Civil Response to Submissions

Project Number:	191797 CAAA_CRTS
Report Issue Date:	04 May 2021
Report Status:	Final
Prepared by:	Eirian Crabbe
Checked by:	Stephen Brain

Taylor Thomson Whitting has been commissioned by Atlassian (the Applicant) to prepare this Civil Response to Submissions Report in response to the issues raised in by government agencies, community organisation groups and the public during the public exhibition of the proposed Atlassian Central State Significant Development (SSD) application (SSD-10405) in relation to the site at 8-10 Lee Street, Haymarket.

**PROPOSED STORMWATER
CONCEPT PLAN**

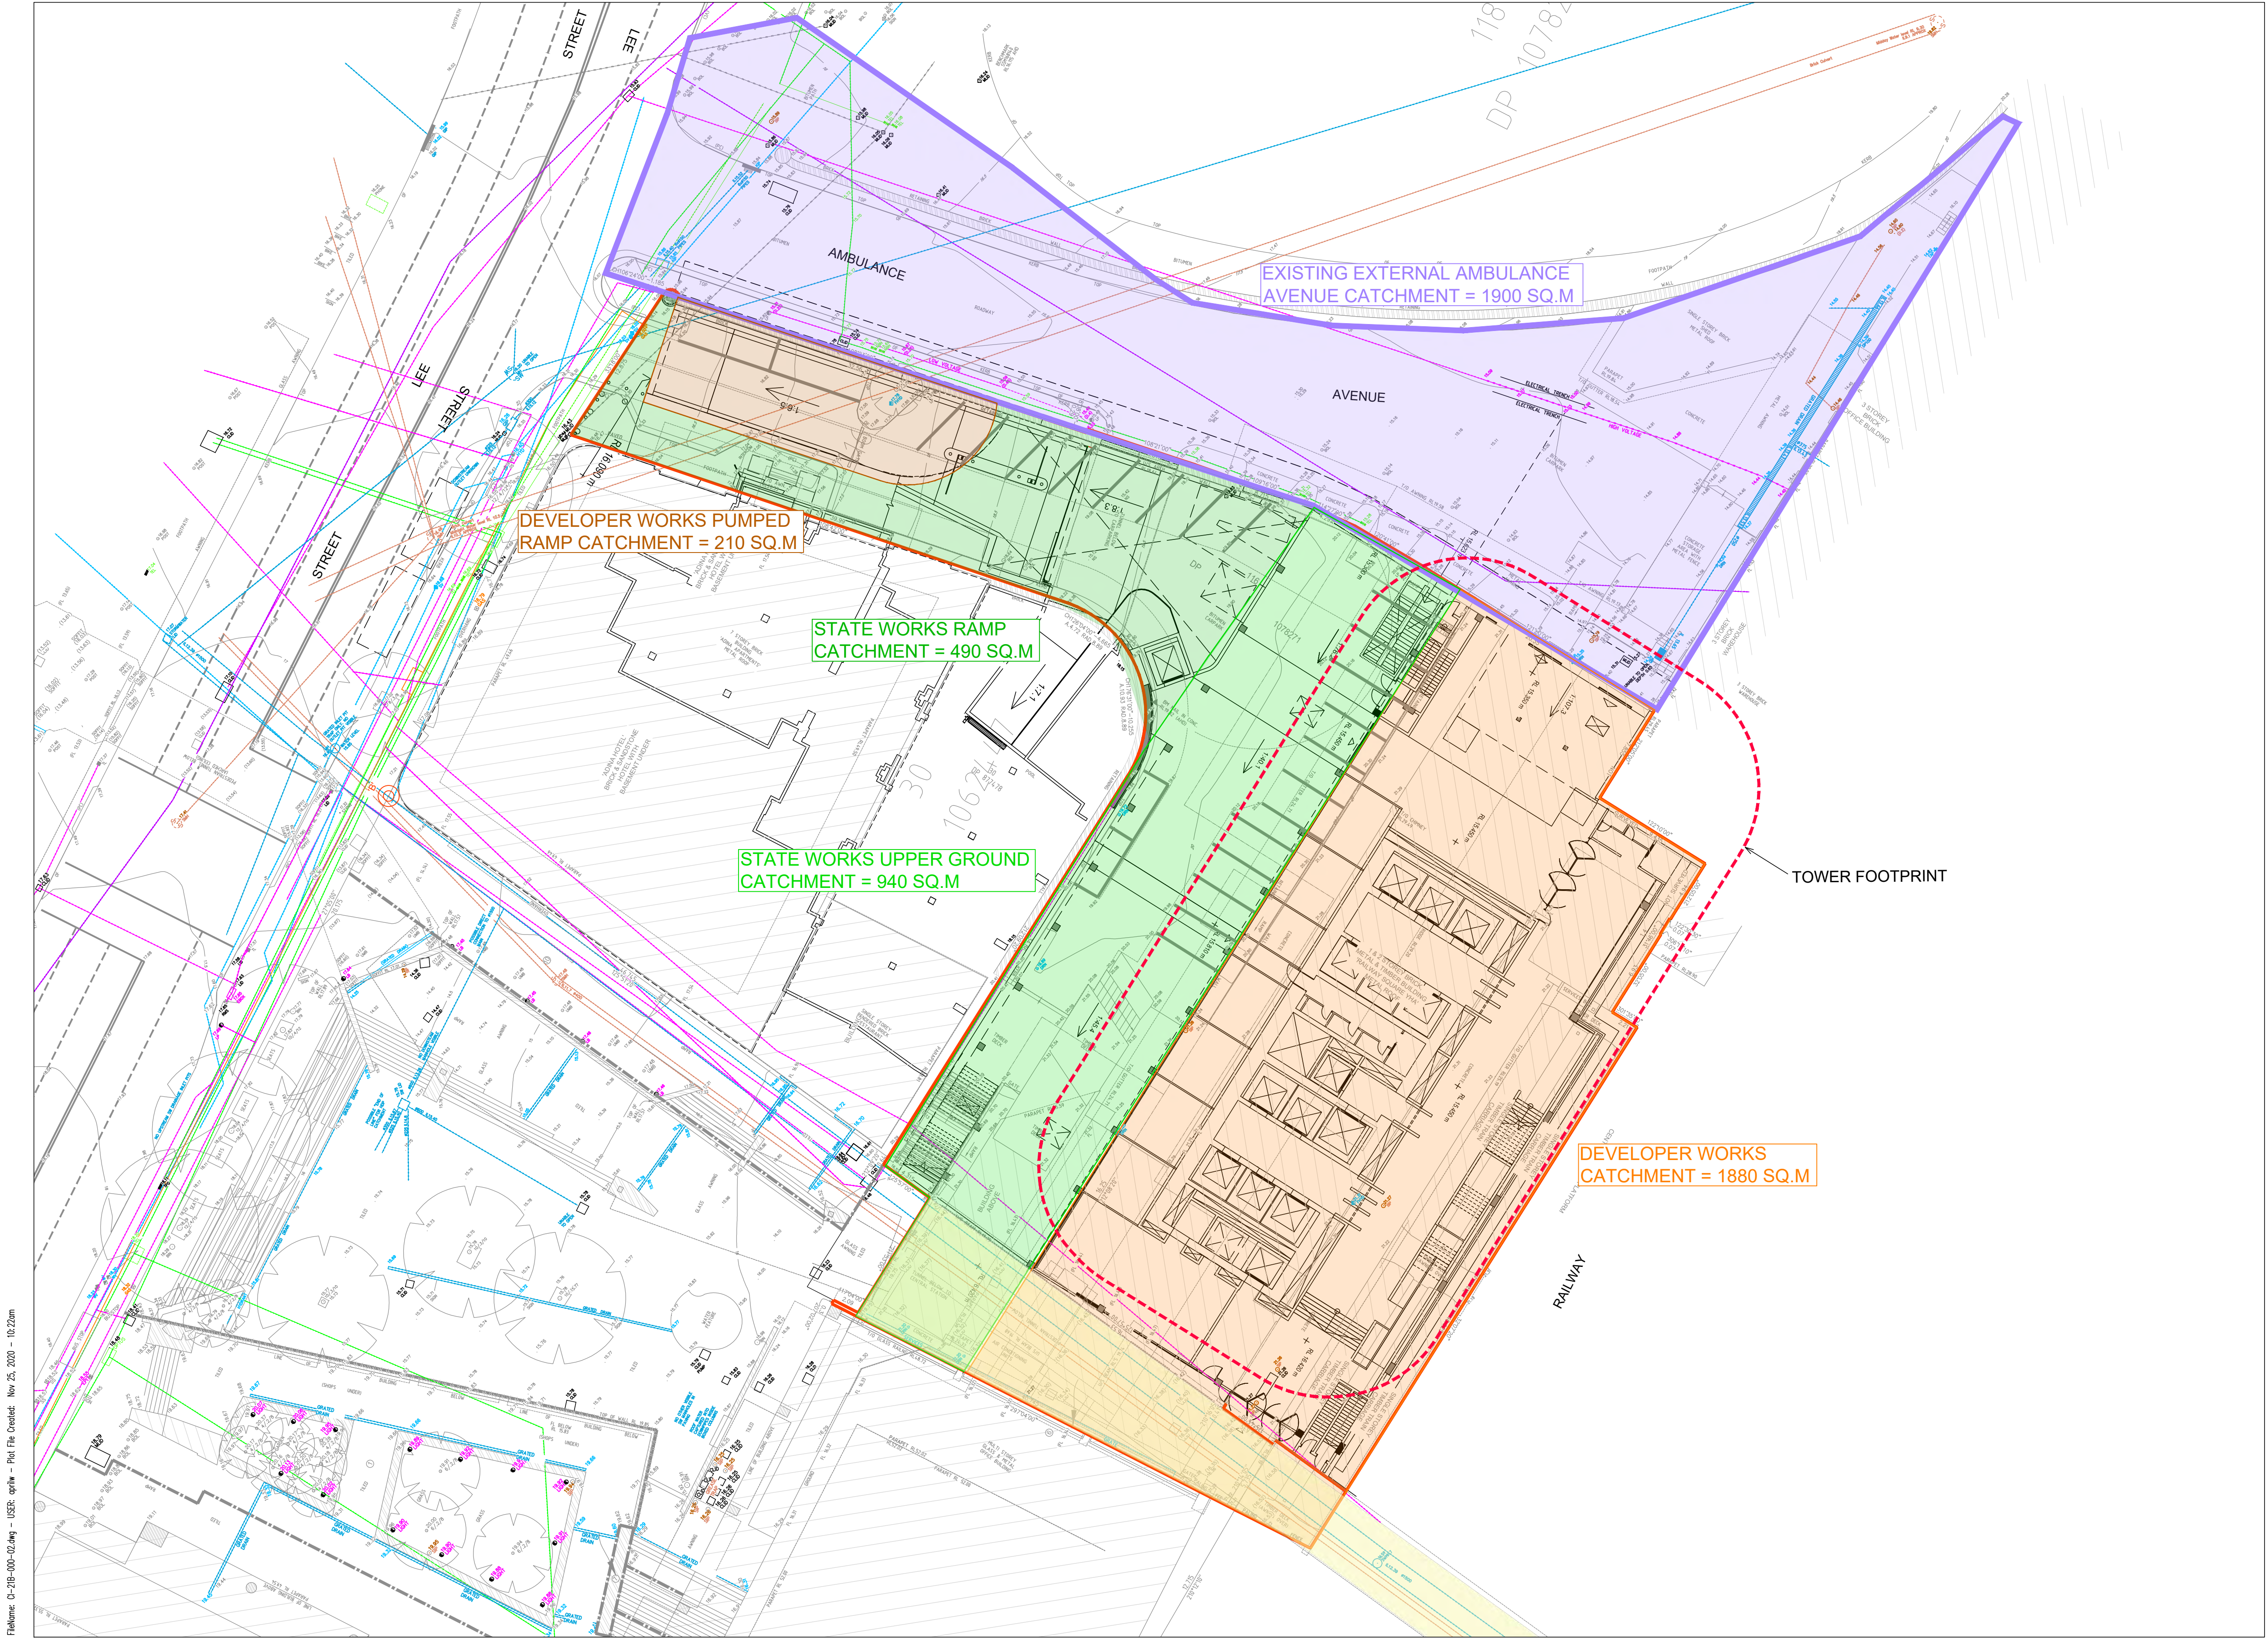
43. The City is concerned that the development is relying on a proposed stormwater network extension to reduce flood levels in Ambulance Avenue, which is unacceptable. All flood planning levels are to comply with the City's Interim Floodplain Management Policy. The following further information should be submitted for review prior to determination:

- A study regarding the practicability and constructability of the proposed stormwater network extension, regarding underground utilities in the area.
- Approval from Sydney Water for the proposed extension to connect to the Sydney Water trunk drain.
- Failsafe design of the inlet structures in the Ambulance Avenue sag, for example blockage of the inlets.

The most suitable way to drain a trapped low point is by providing stormwater inlets and pipes that are drained by gravity and conveyed to areas that lie below the trapped low point. This is a standard method of stormwater drainage used for trapped low points and is currently the existing method used for draining this area. The proposed stormwater amplification increases the inlet and pipe capacity to improve the efficiency of draining this trapped low point and reduces flood risk to the development and to the wider

- a) A detailed services and utilities survey is currently being undertaken that will enable a detailed review of the practicality and constructability of the proposed stormwater. However, the proposed depth of the stormwater at up to 4m below the surface of the Lee Street is unlikely to clash with existing utilities and services that are generally located at much shallower depths. Further design progression of the proposed stormwater will take place following the SSDA approval as part of the design development.

- b) Approval from Sydney Water for the proposed stormwater connections to the existing Sydney Water trunk drain will be obtained through a Section 73 application. Consultation with Sydney Water is ongoing and it is likely that approval from Sydney Water will be obtained following the SSDA approval which can be conditioned with the consent.

- c) The flood model detailed in the TTW Civil SSDA Report, section 5.2 confirms that a blockage factor of 95% blockage has been applied to large grated inlet structure in Ambulance Avenue, in accordance with City of Sydney (CoS) drainage specification. The proposed inlet structure will be 25m long and 600mm wide, the likelihood of the full inlet area being completely blocked is extremely unlikely in any storm event. The ground floor levels are compliant with CoS interim Floodplain Management Policy and are set above the 1% AEP flood level with basement entrances raised or protected with internal flood gates to provide protection up to the PMF and 1% AEP +500mm flood level.
